Environmental Health Review Comments

AL2615: 13635 Murphy Road - Accessory Living Quarters for Permanent Occupancy Special Use Permit

W1
1 of 5

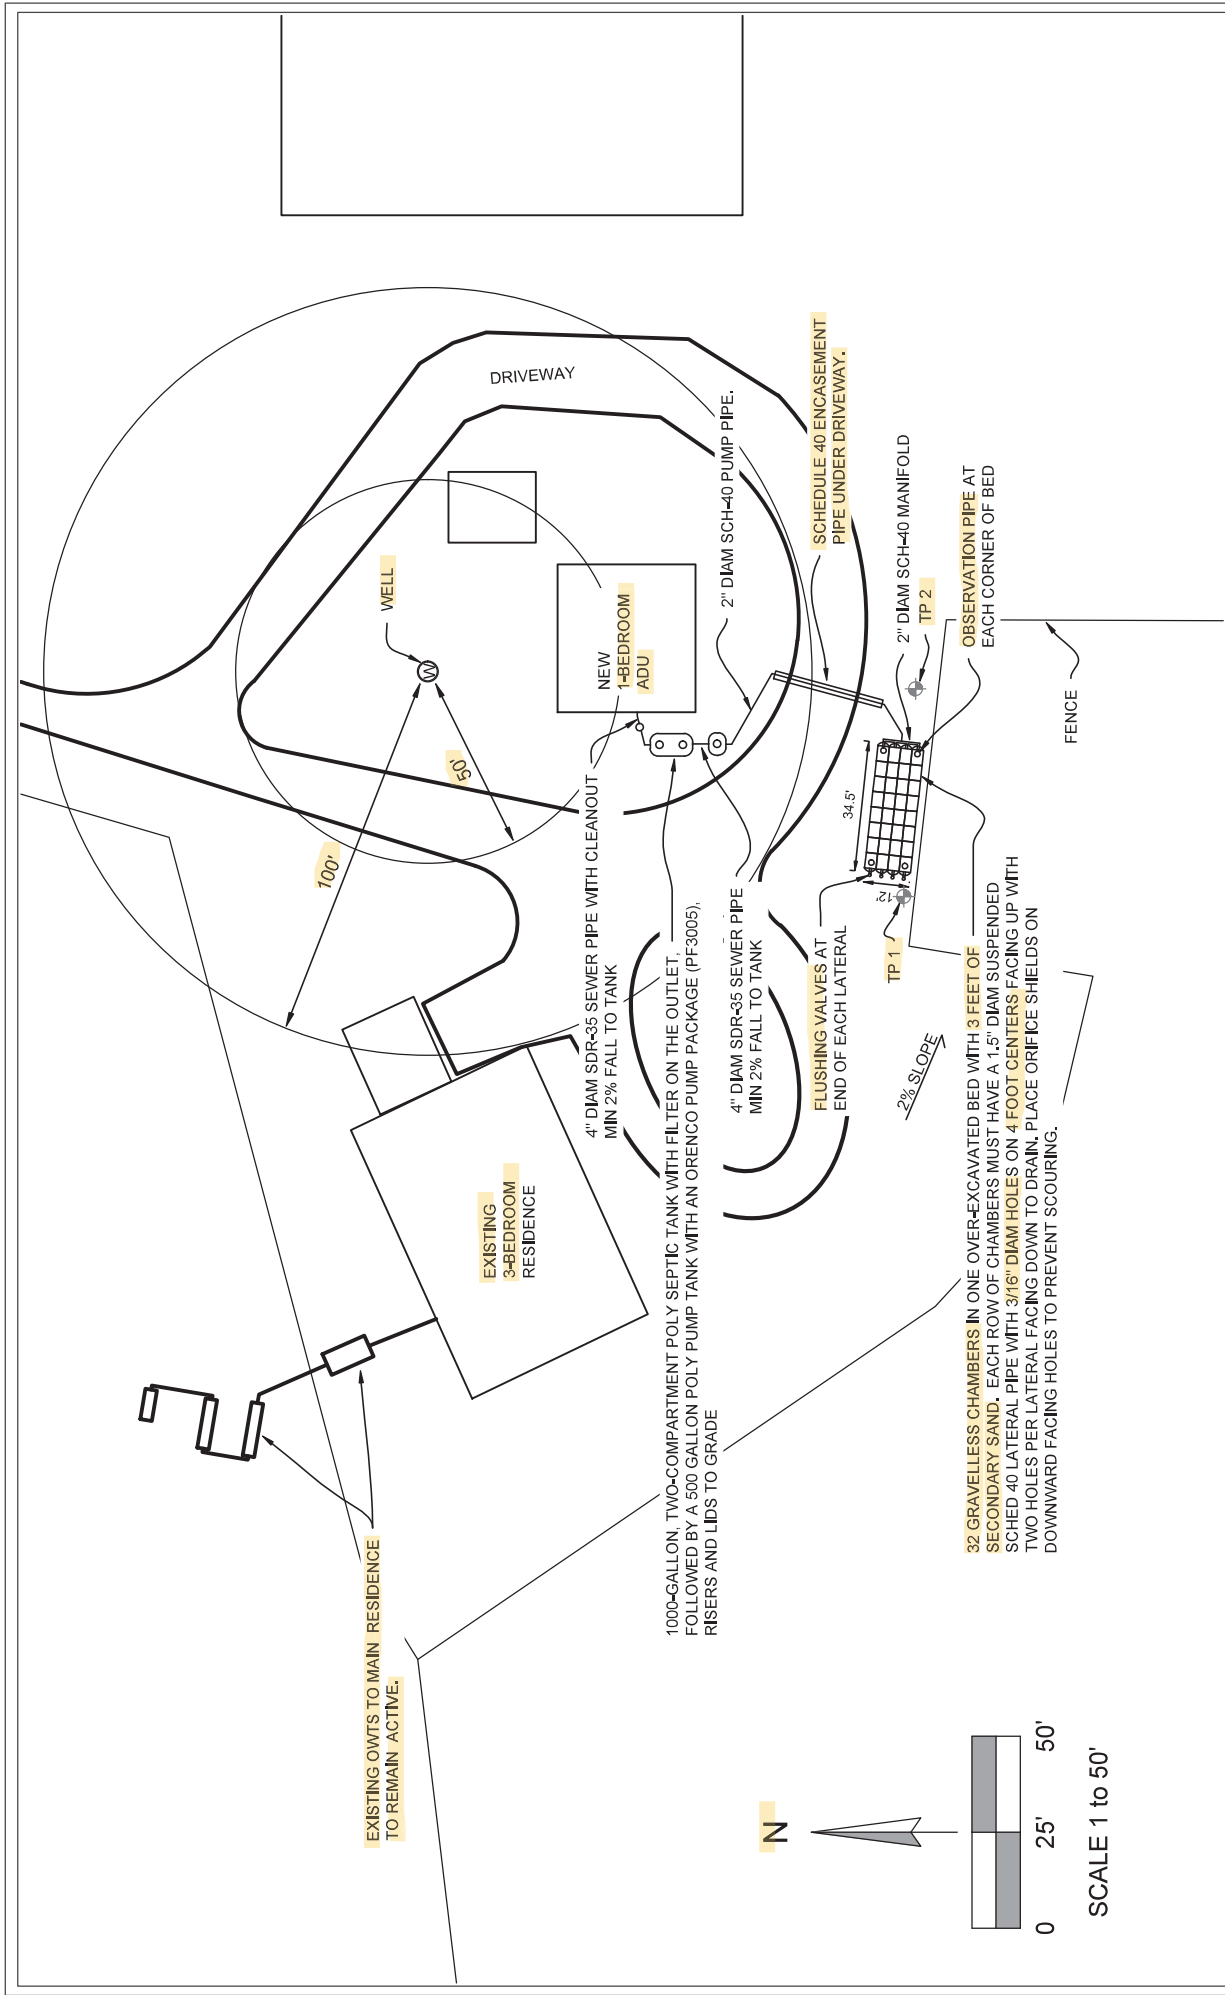
- The OWTS as permitted will be subject to the Operation and Maintenance Requirements of EPCBoH Chapter 8 Regulations for the life of the system.
- It is imperative that the STA location be protected from construction related activity to minimize the chance of construction equipment compacting the soil. Suggest marking the STA location to raise awareness of the area.
